Australian Museum Alterations and Additions

Review of compliance of access for people with a disability

September 2018

Prepared by: Access Associates Sydney

FLOOR PLAN - BASEMENT LEVEL - PROPOSED  
AM ADDITIONS & ALTERATIONS

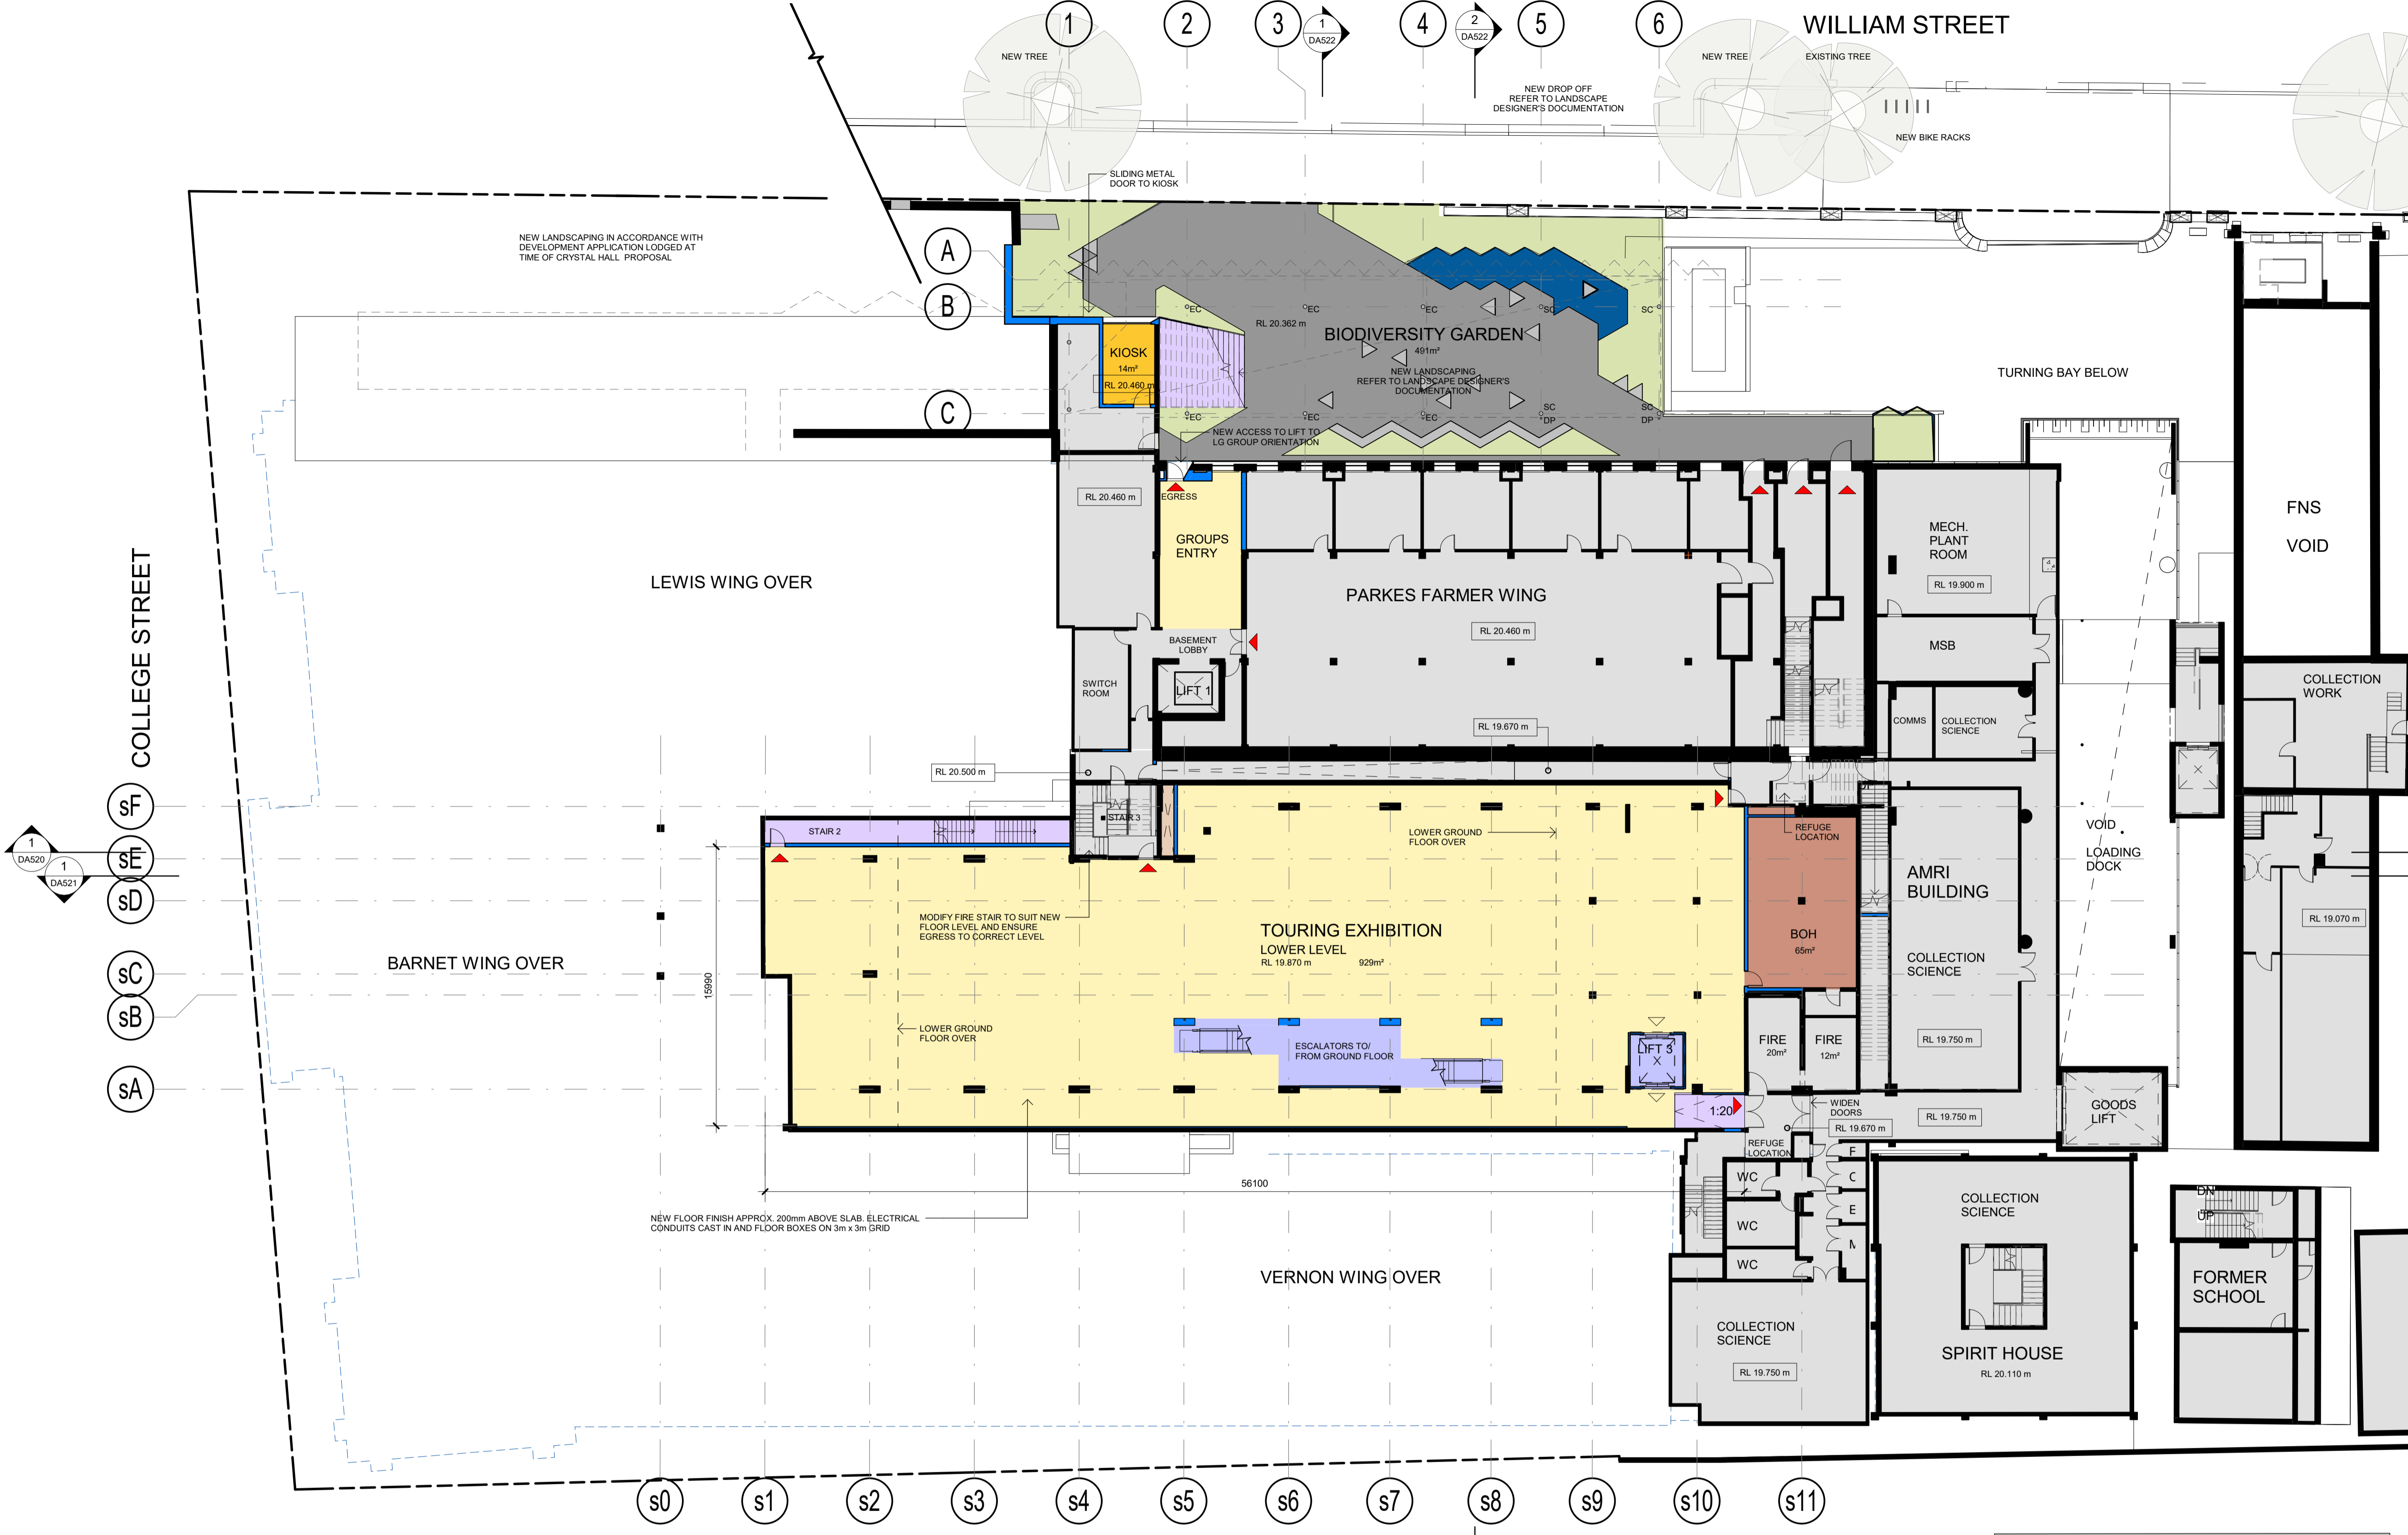
New work on the basement level is proposed to include a **Touring Exhibition** area which is proposed to provide a large open area for the installation of temporary exhibitions.

- (iv) Escalators do not form part of an accessible path of travel however they are required to meet AS1428.4.1 to include tgsi top and bottom
- (v) Ensure new lift linking to exhibition space meets the BCA part E3.6 and AS1735.12.
